Falcon Highlands

Final Drainage Report

24004308

Provide PCD file No.
SF2418

CHALLENGER HOMES
FALCON HIGHLANDS SOUTH - FILING 1
EL PASO COUNTY, COLORADO
DRAINAGE MAPS
EXISTING DRAINAGE MAP

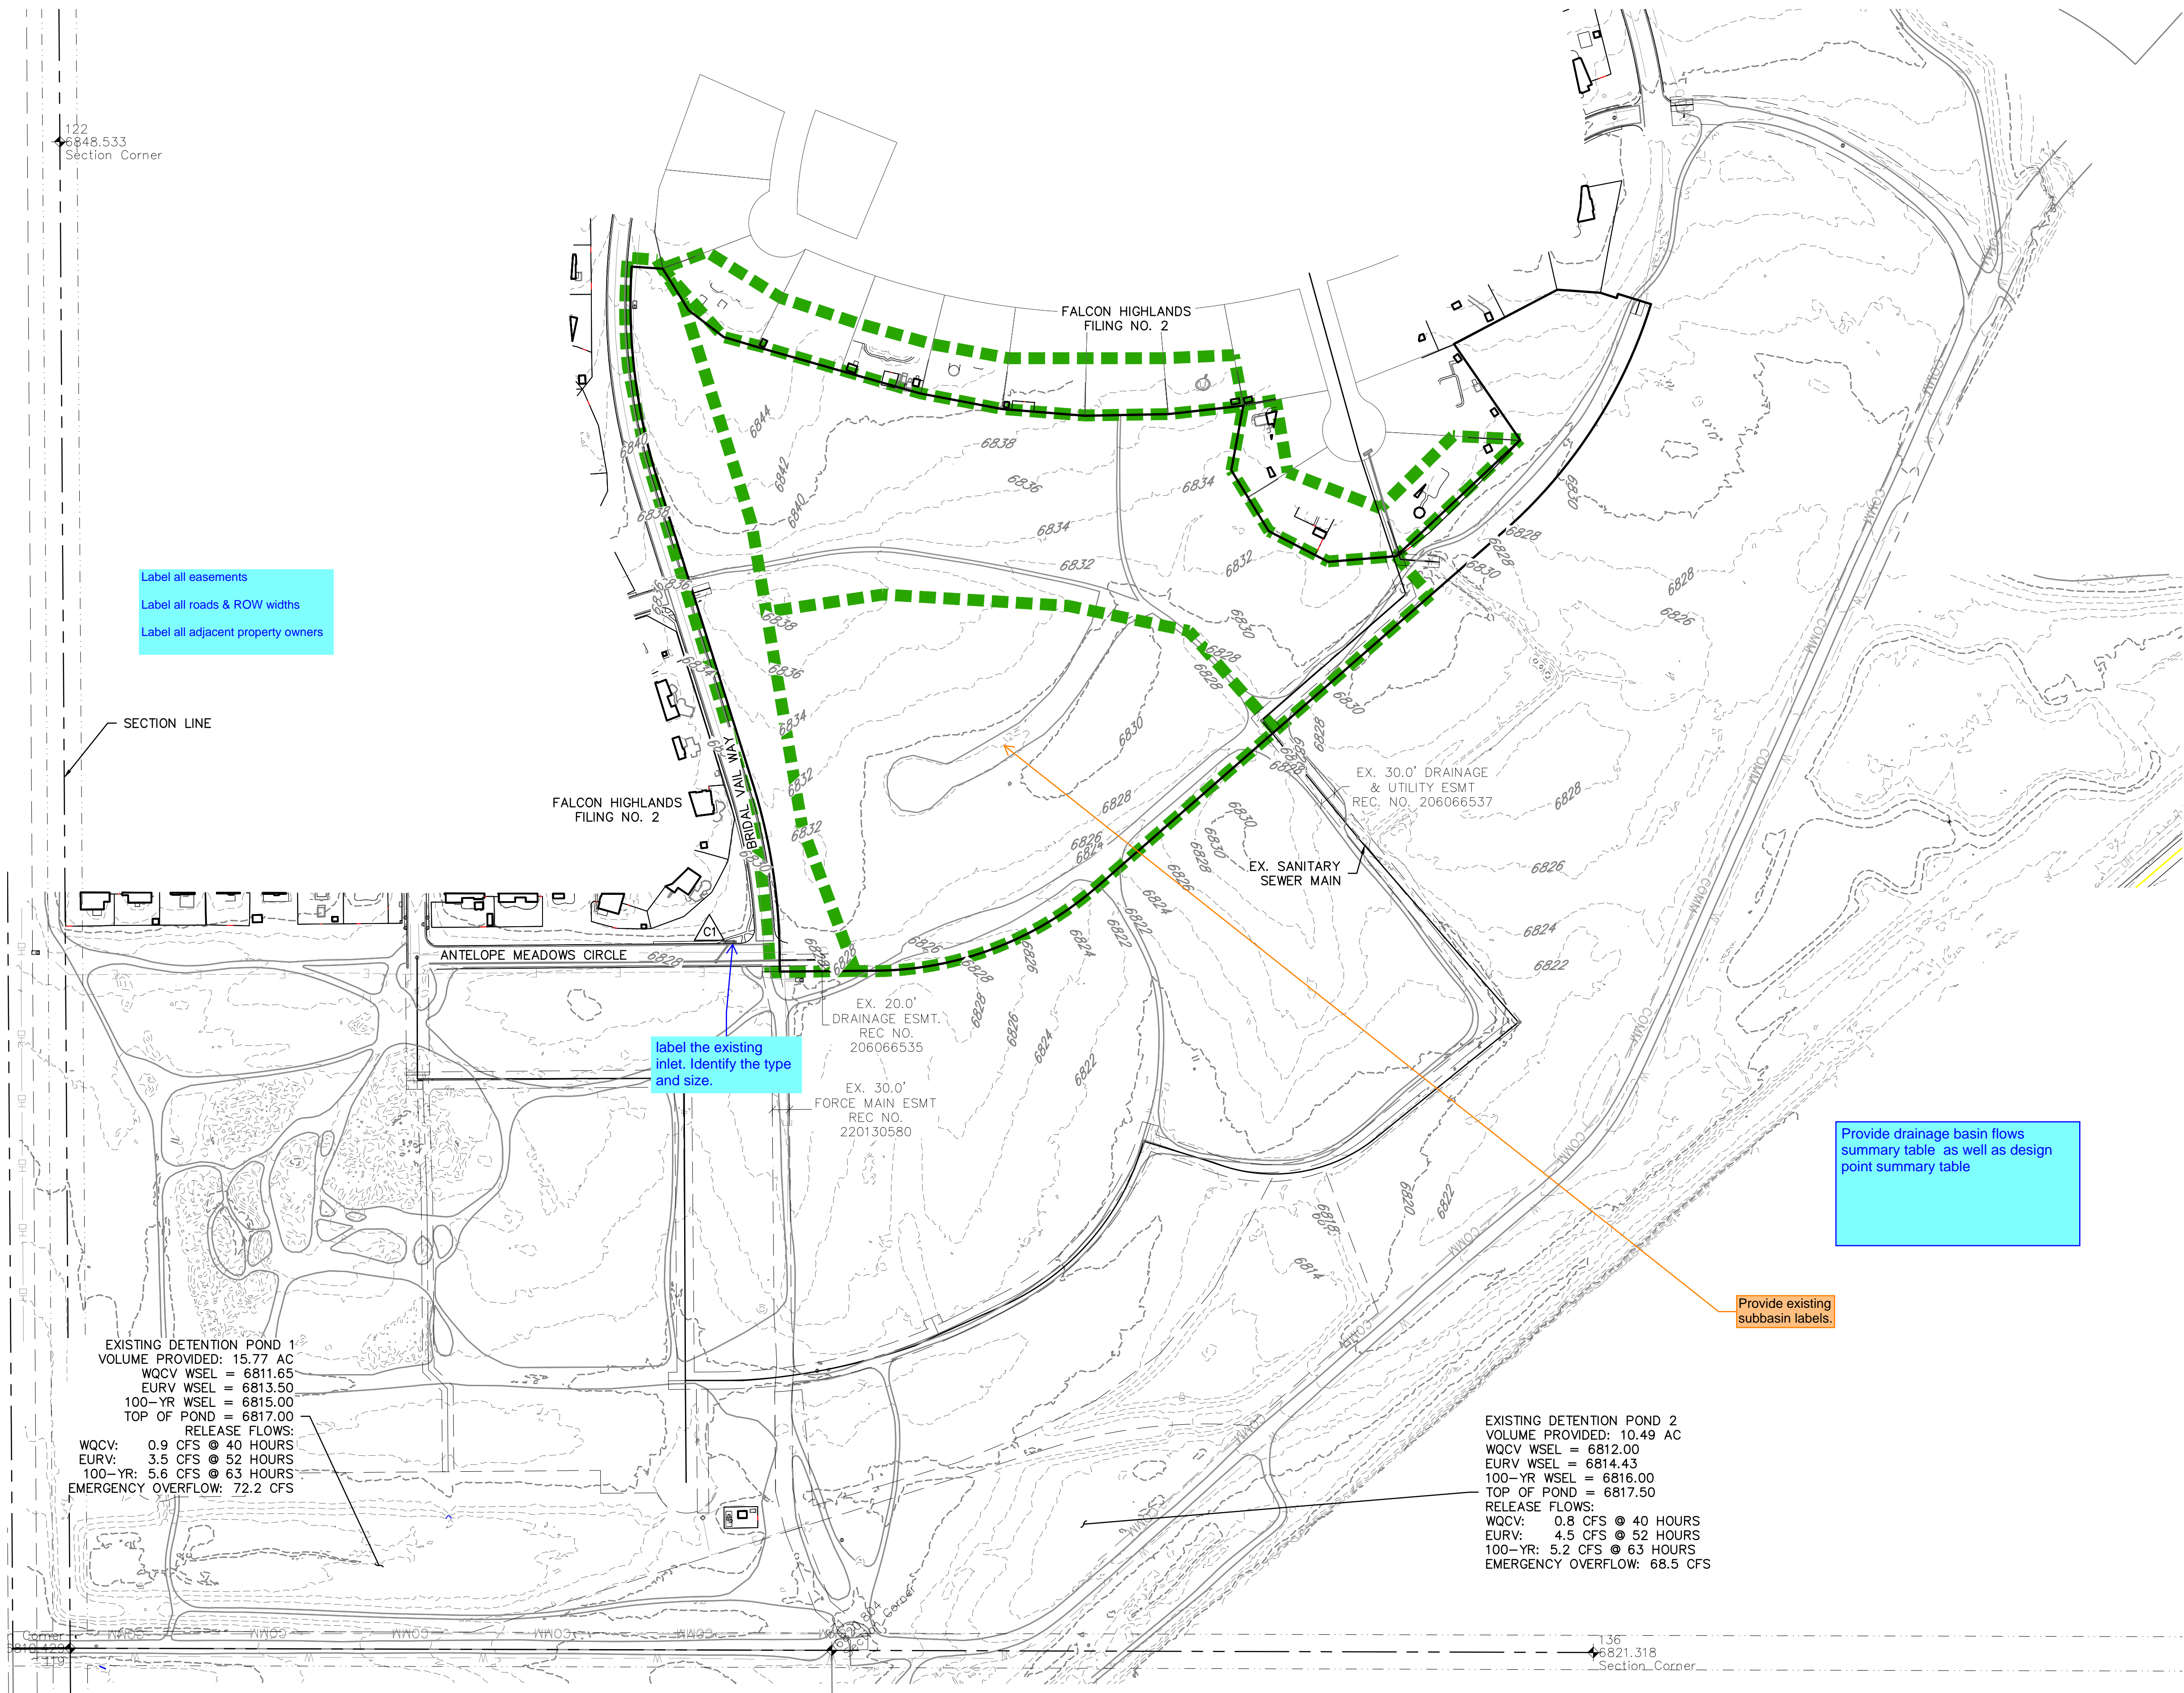
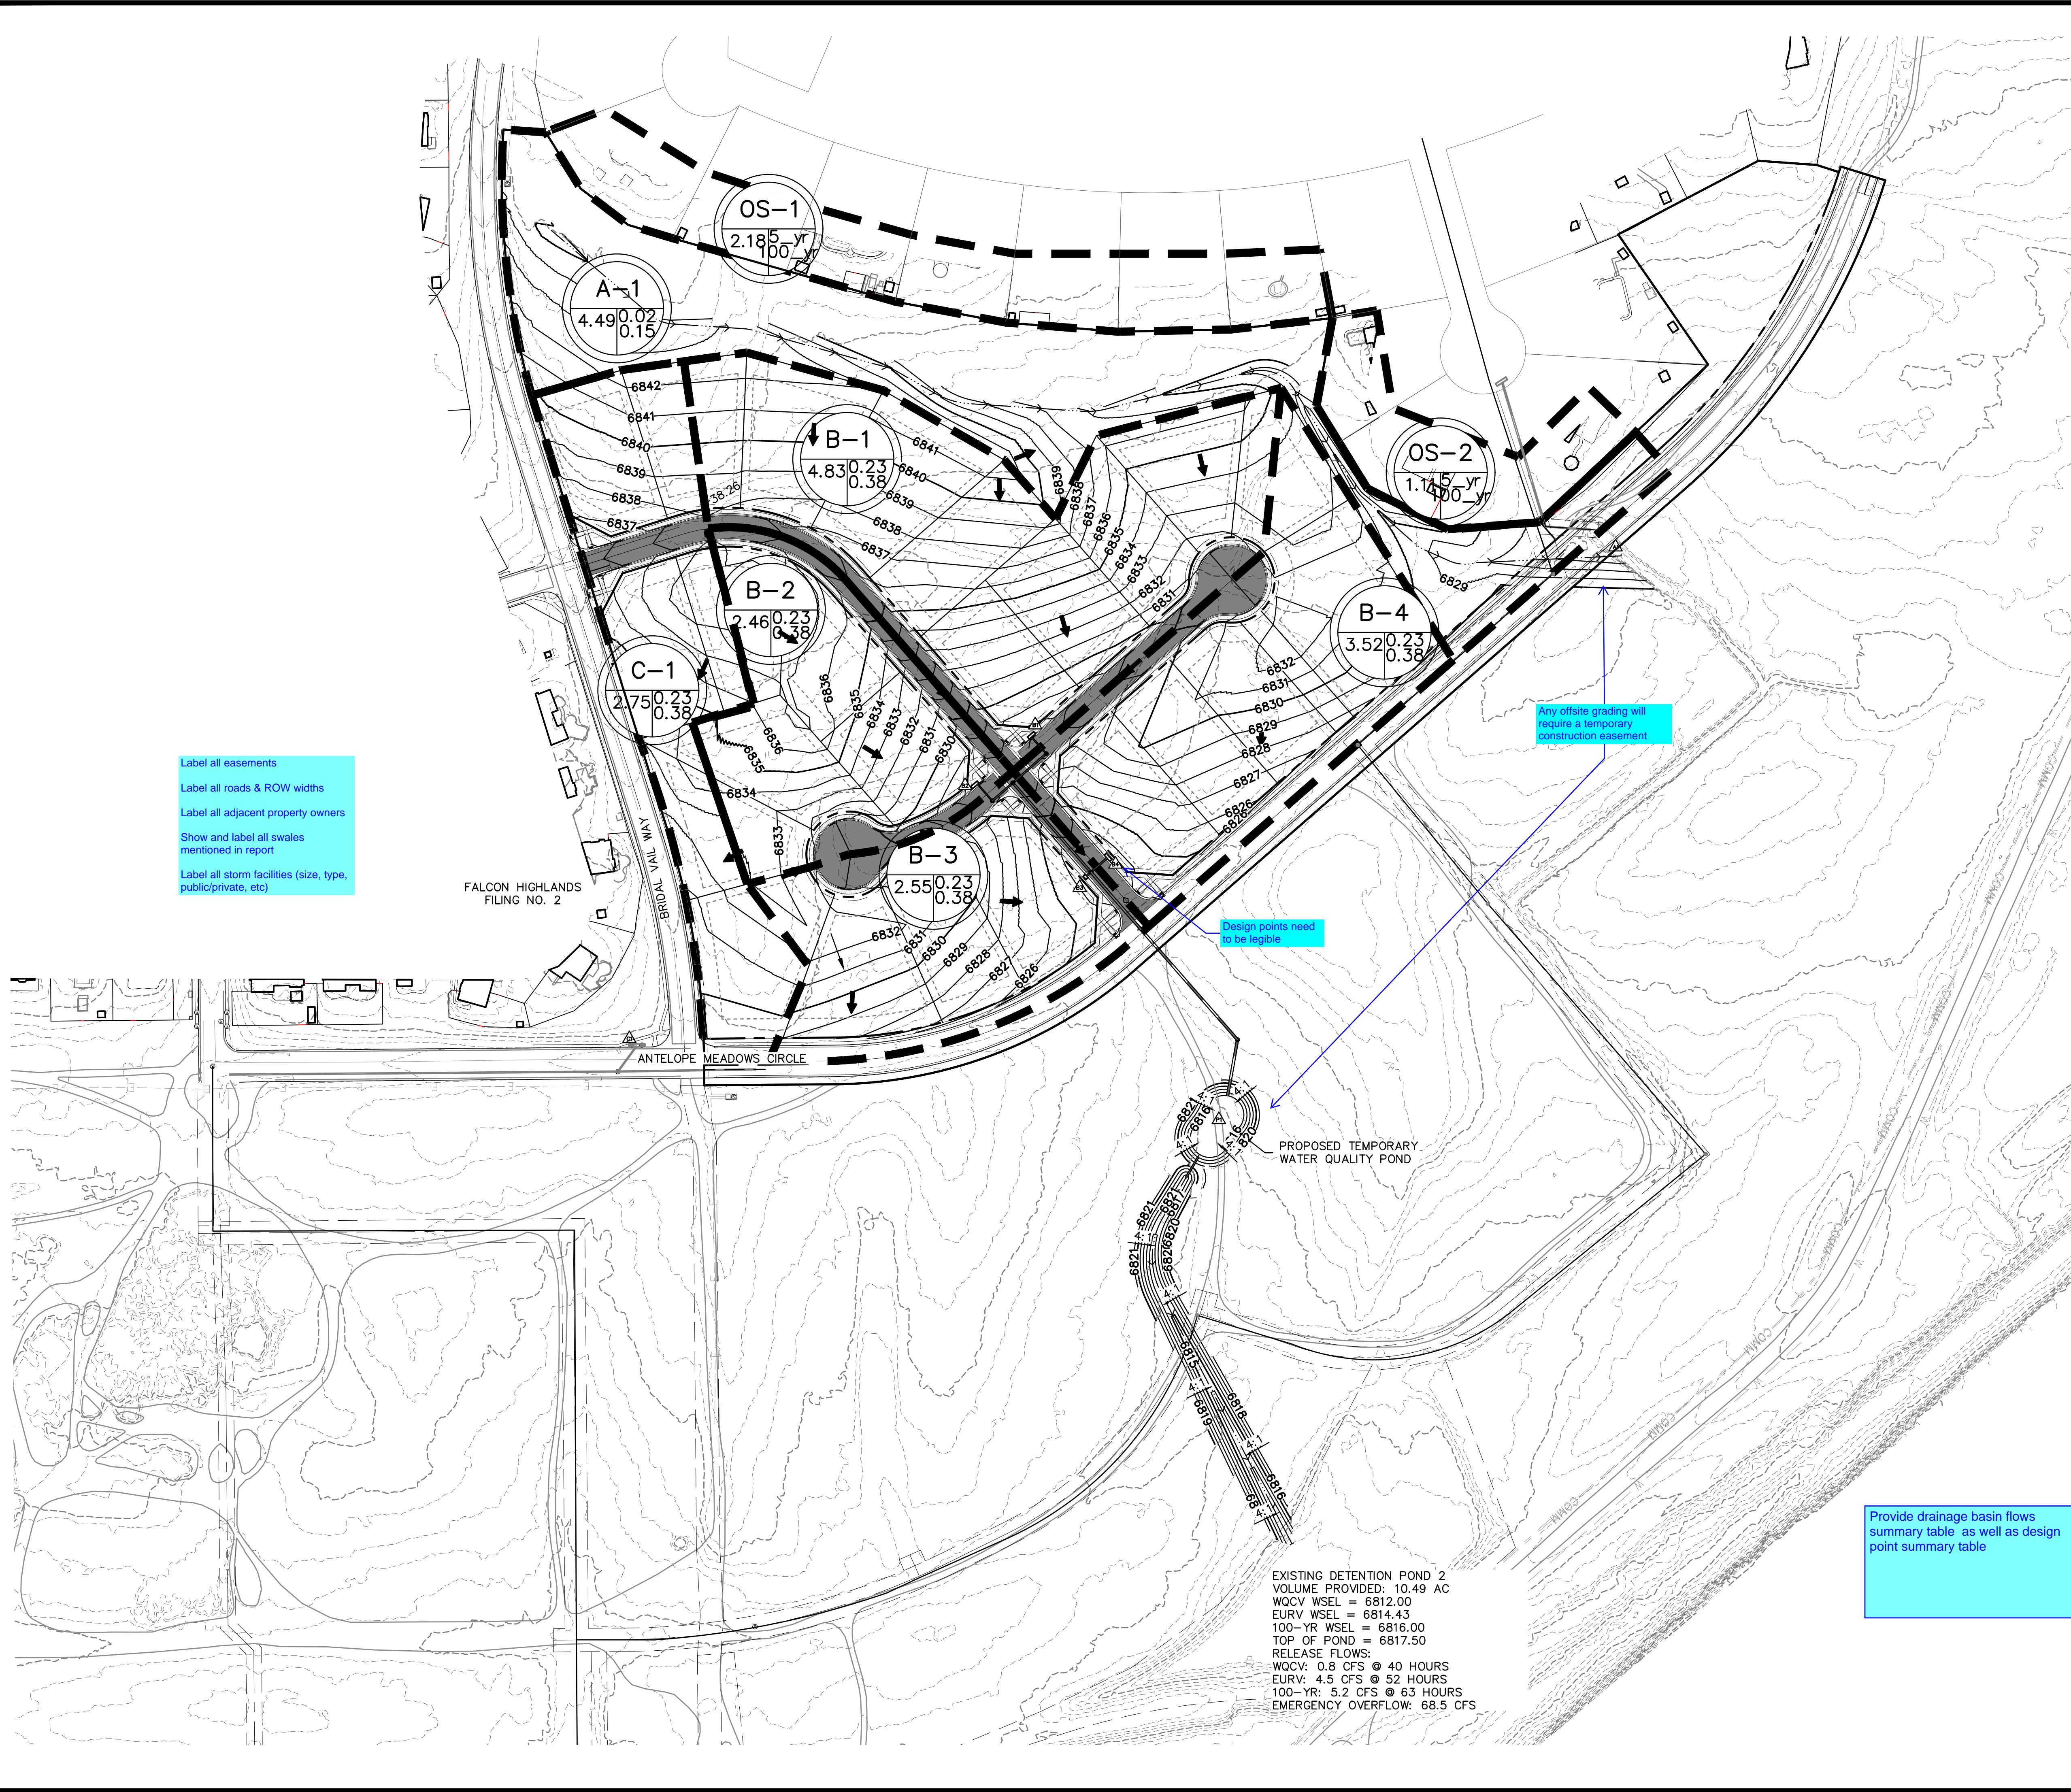
sub-basin labels are missing on the drainage plan as well as flow summary tables. Further review and possible comments will be provided on the subsequent submittal.

won't A-1 flow to existing pond 2? on the maps it appears that it will.
